1 No. dwelling with detached garage (part resubmission following R/91/17/PL & R/204/18/PL).

Springfield House Springfield Close Rustington

Thank you for your internet representation made on 12th November 2019 which has been recorded as '**an objection**' with the comments as follows:

Job Title	Springfield House		
Client	Castle Property Developments		
Drawing Name	Garage - Plan & Elevations		
Drawing Status	Planning		
Drawn by	DF	Date	Sept 19
Checked by		Date	
Drawing Scale	1:50 & 1:100 at A1		
Drawing No	Status	Revision	
181303/	09

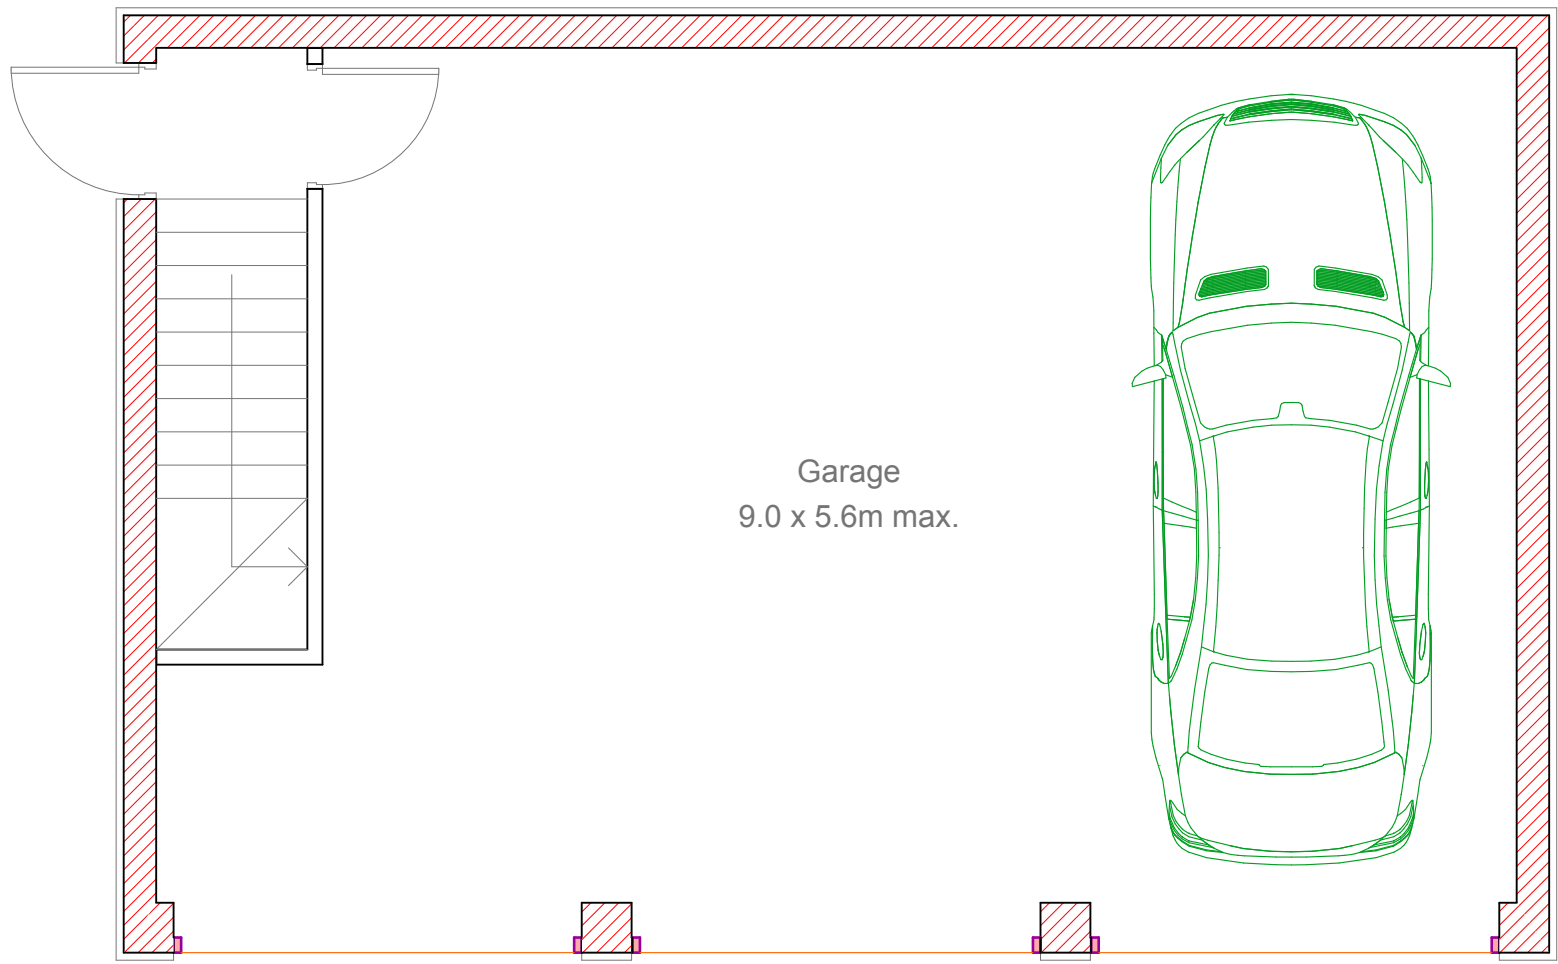
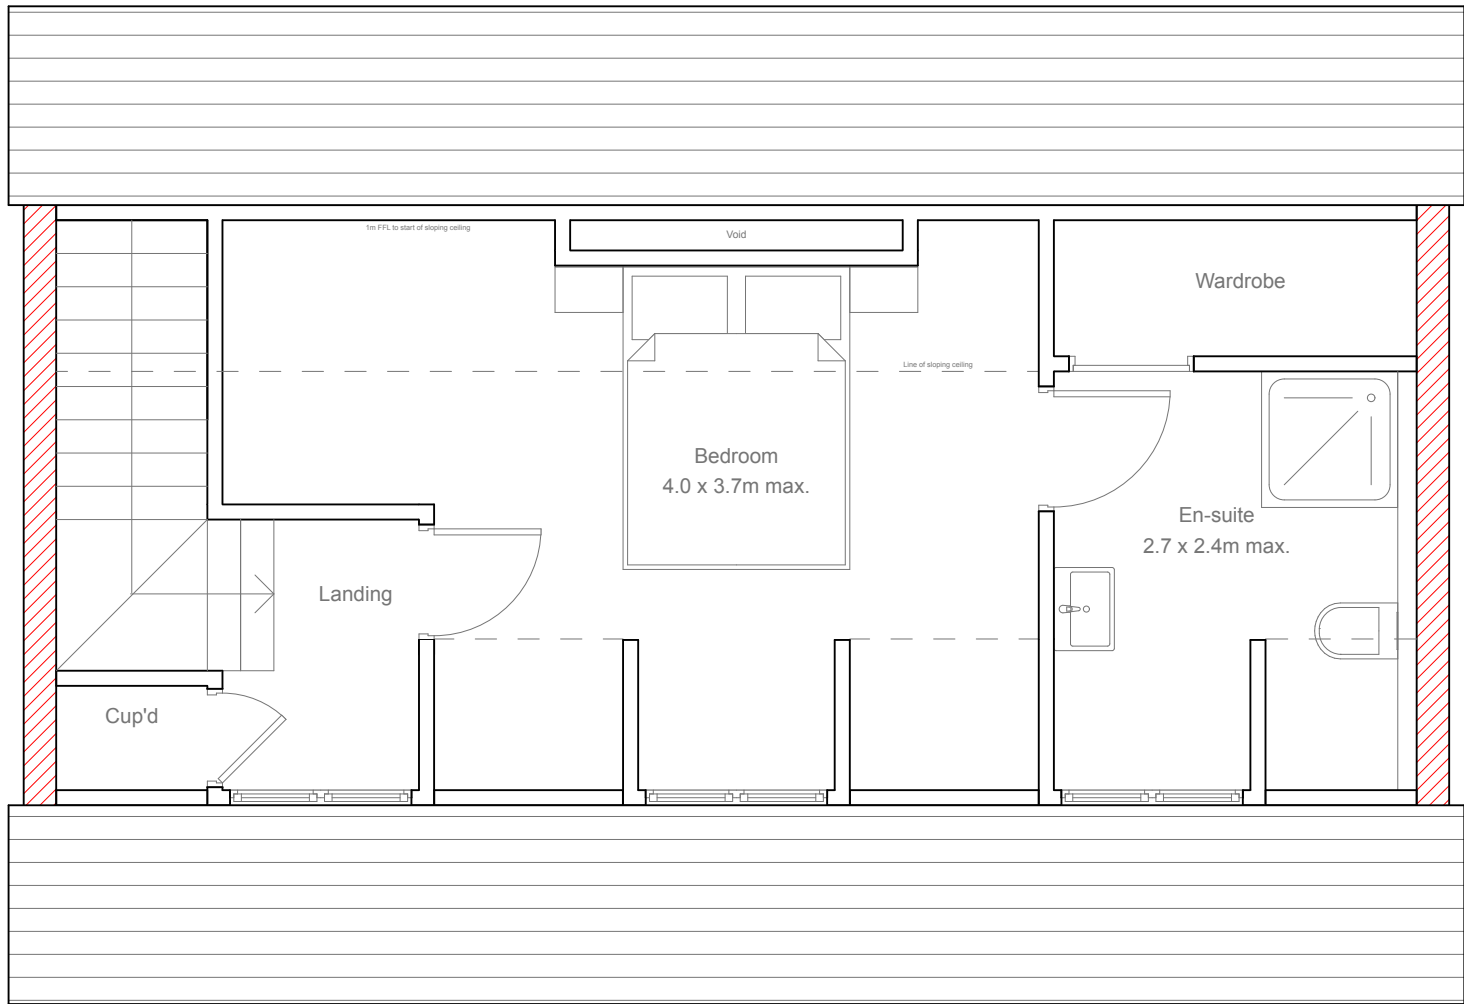
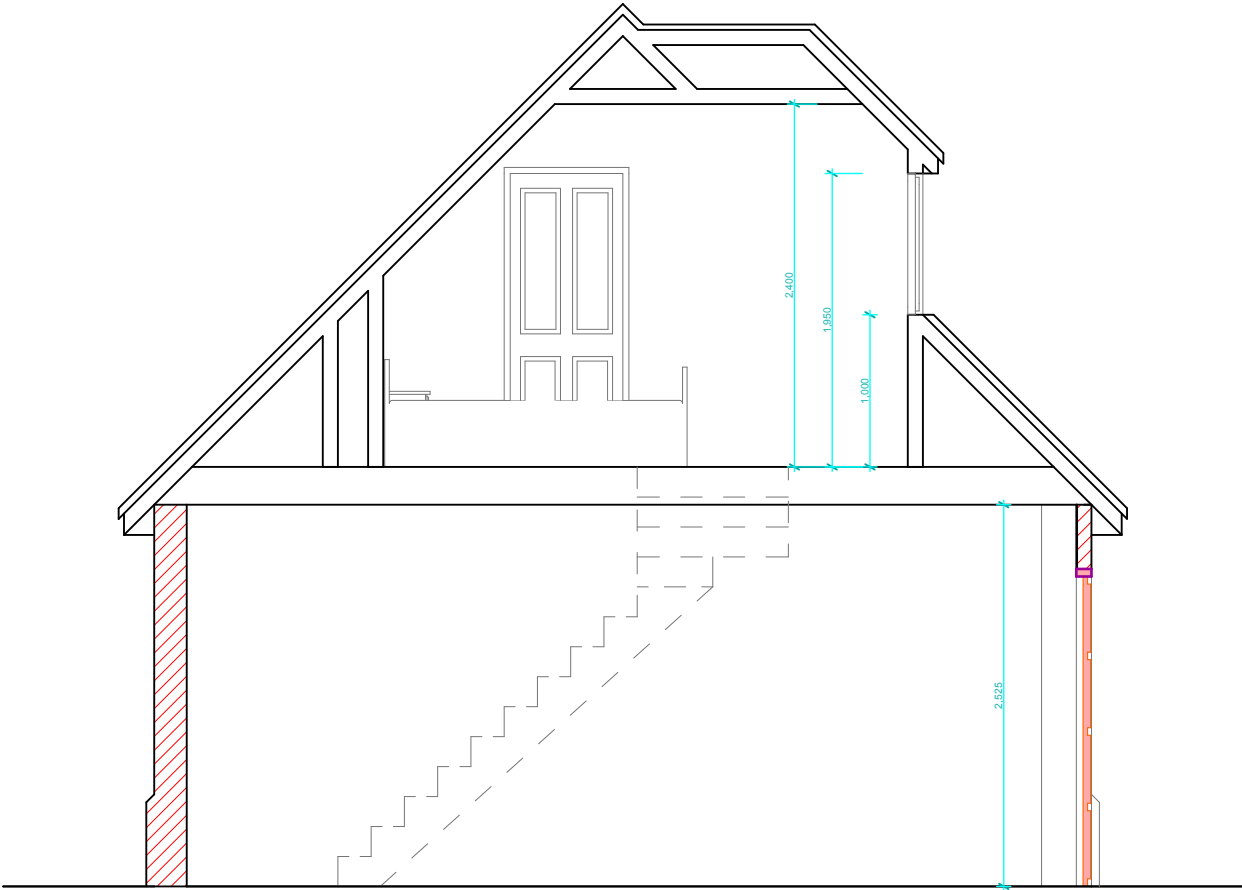
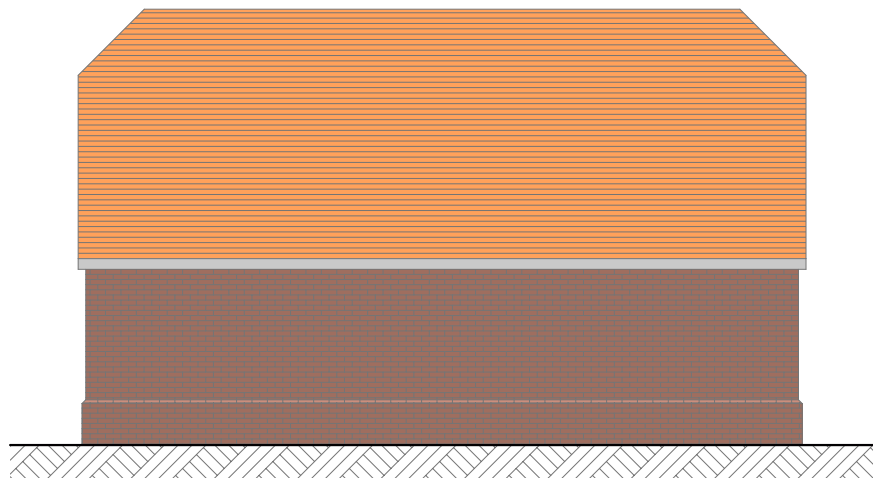
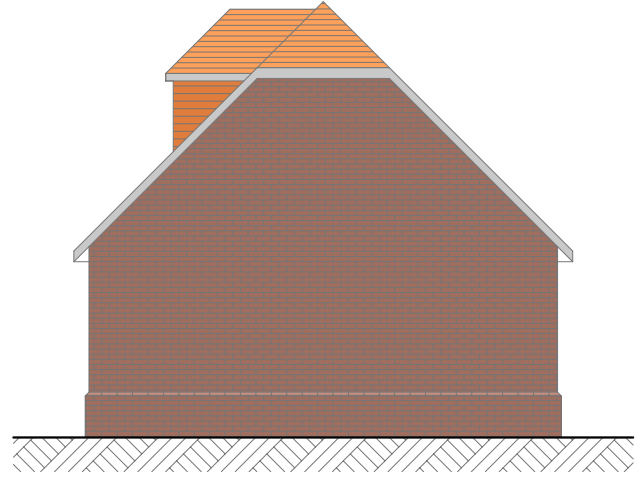
Finally the large triple garage with flat above is a huge addition to the development originally approved under reference R/91/17/PL. Why is further living accommodation required when the house already has 5 bedrooms? This is stretching the original planning permission to breaking point, and would not have been approved when the first permission was granted in 2017.
